Figure 2. Septic System Layout (Option 1)

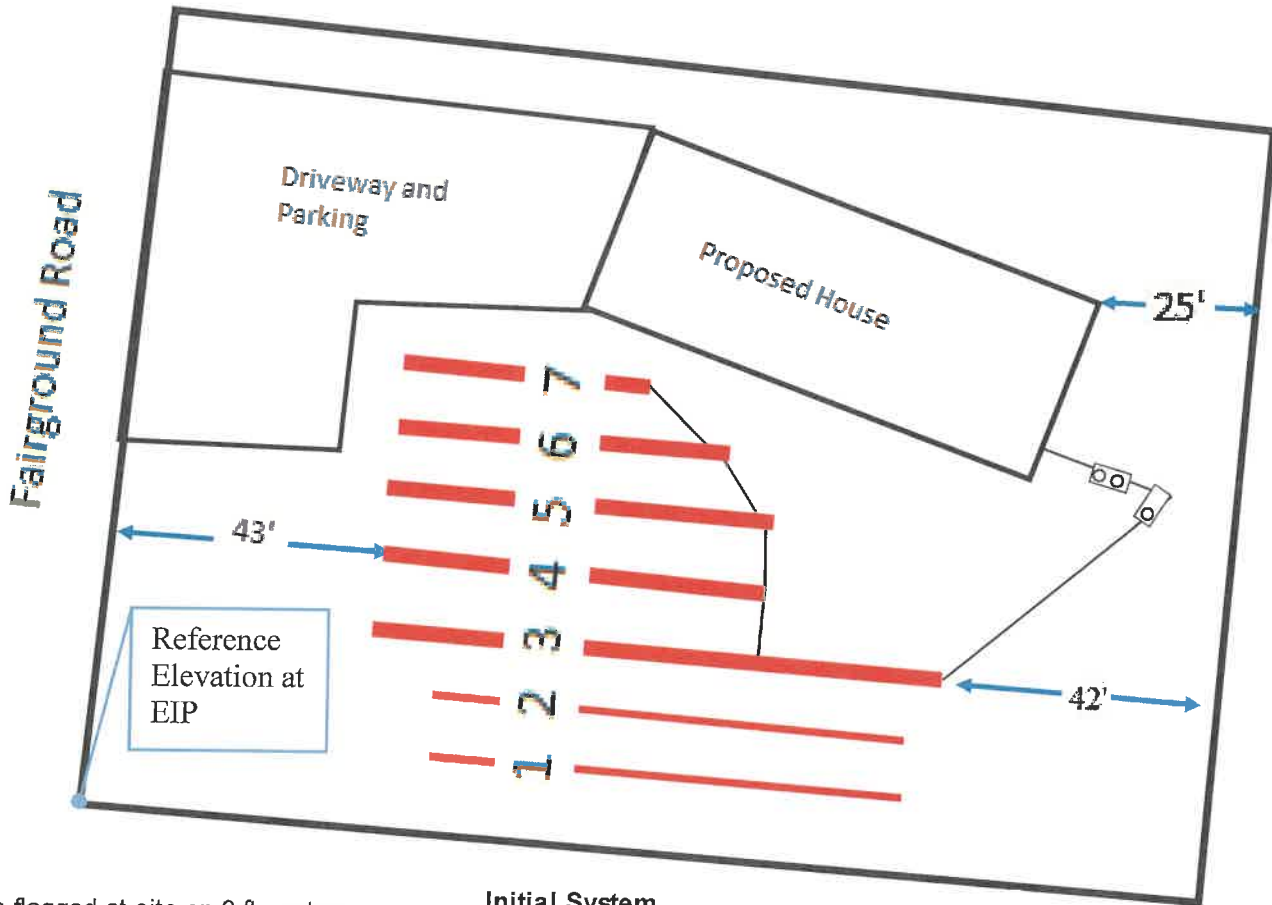
*Mistakes made by consultant on length of line  
 in design  
 Any change  
 must be redesigned  
 By  
 LSS*

Show profile locations and other site features (dimensions, references or benchmark, and North)
